Application number: 2025/93355	
What is the application for?:	Erection of 75 residential dwellings with associated landscaping, open space, hi
Address of the site or building:	Land off, Woodward Court, Mirfield, WF14 0PY
Postcode:	LS15 8ZB

Type of comment: An objection	
Do you wish your comments to be published on the website anonymously?	Yes

TITLE	HEPWORTH LANE / FLASH LANE / SHILLBANK LANE EXISTING HIGHWAY LAYOUT
REF	FIGURE 11
SCALE	1:200 @ A3

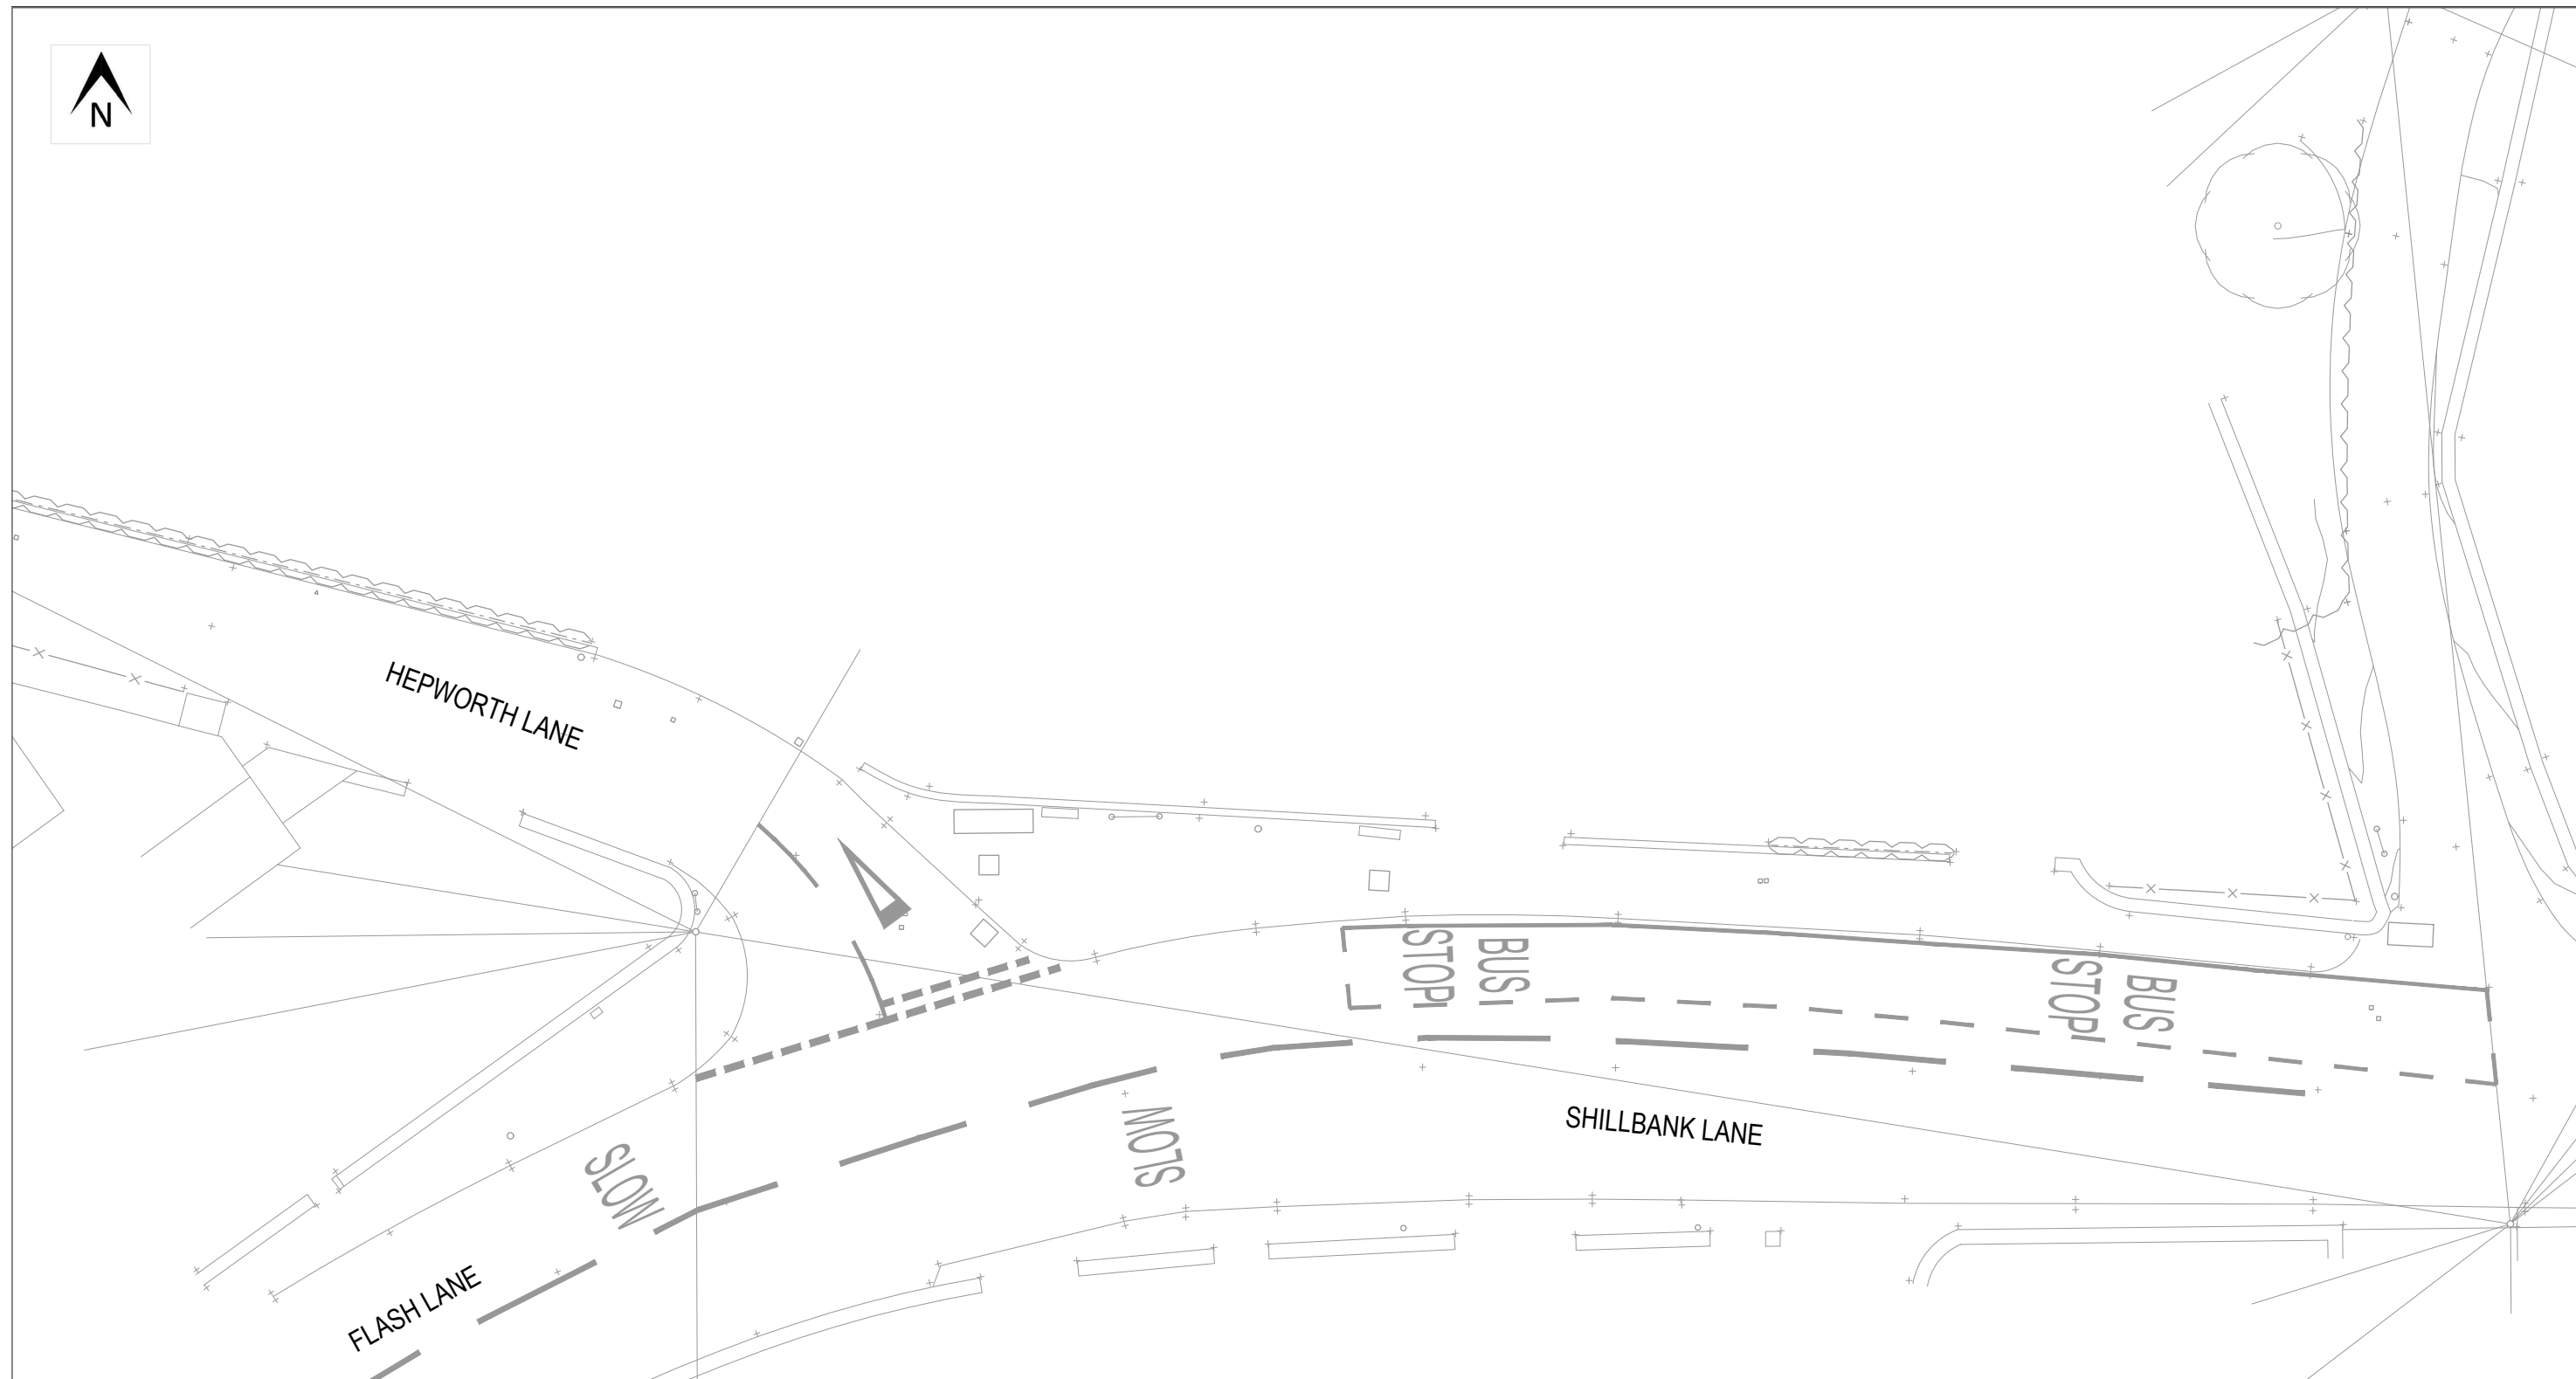
The road network surrounding the proposed development is already constrained, with several junctions operating below an acceptable safety and capacity standard. In particular, Hepworth Lane at its junction with Flash Lane and Wellhouse Lane at its junction with & Flash Lane both have carriageways which are too narrow to accommodate two passing cars. This severely hinders the movement of traffic to and from the main road resulting in gridlock and congestion. It is not possible to redesign the road infrastructure in these locations.
